From: Bob Neville
Sent: 16 June 2021 10:30
To: DC Support
Subject: FW: Planning notification for application reference: 20/03660/REM

From: patrickprendergast@bucksplantcare.co.uk <patrickprendergast@bucksplantcare.co.uk>
Sent: 16 June 2021 10:27
To: Bob Neville <Bob.Neville@cherwell-dc.gov.uk>
Cc: Jonathan Emanuel <jonathan.emanuel@cherwell-dc.gov.uk>
Subject: RE: Planning notification for application reference: 20/03660/REM

I am commenting on the above application from an arboricultural aspect.

I have studied the landscape plan

LANDSCAPE MASTERPLAN
HARD AND SOFT LANDSCAPE

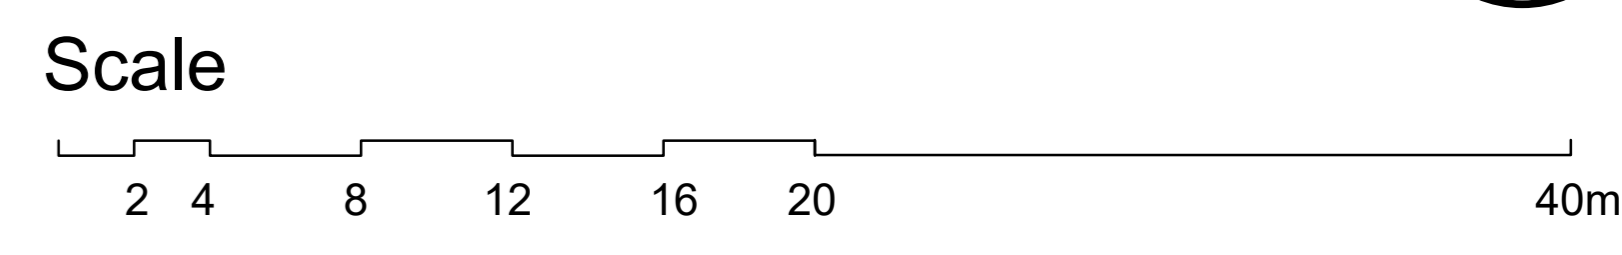
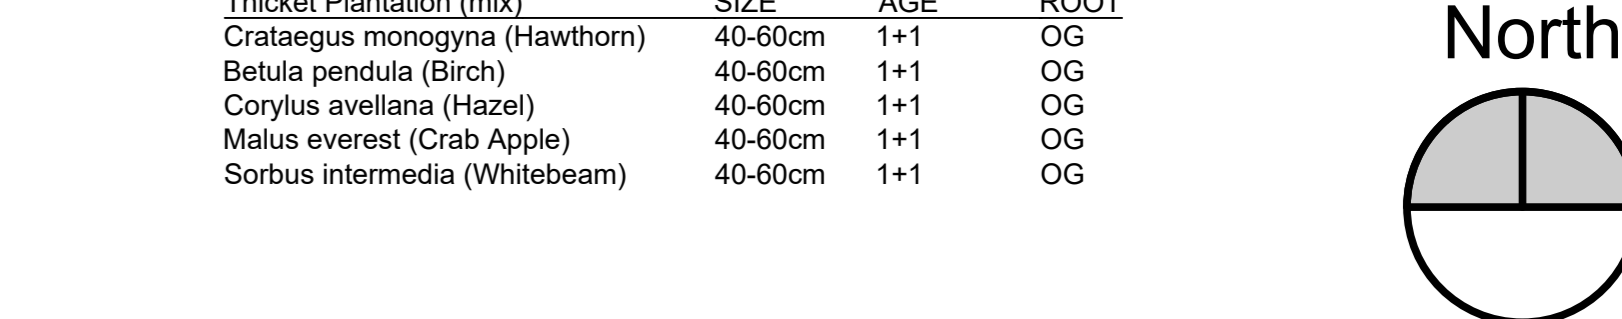
1. The *Malus domestica* sp should be clarified with the exact cultivar. The location proposed is not appropriate for falling fruit in a parking area. Best to change them to an appropriate maple like *Acer platanoides* Farlakes Green.
2. The rear gardens have been left bare as it is an ideal opportunity to add biodiversity to the site with a selection of garden fruit trees to locations marked with blue X, ie apple, pear, damson, plum, almond

3. I note that there were no conditions made for tree protection in the conditions but the DAS stated that the 2 trees in the front would be retained. It there is a means of ensuring these are protected during construction that would be all the better ?

4. The proposed maple next to the retained tree on the left of the entrance is too close. It could be moved to the other side of the entrance with the oak also changed to a maple to highlight the entrance. The oak along with more oaks can be located around the swale and the western boundary for the long term biodiversity.
5. The specification relies too much on the landscape contractor having access to copies of the various British Standards. The relevant detail should be in the specification along with a 5 maintenance plan to establishment.
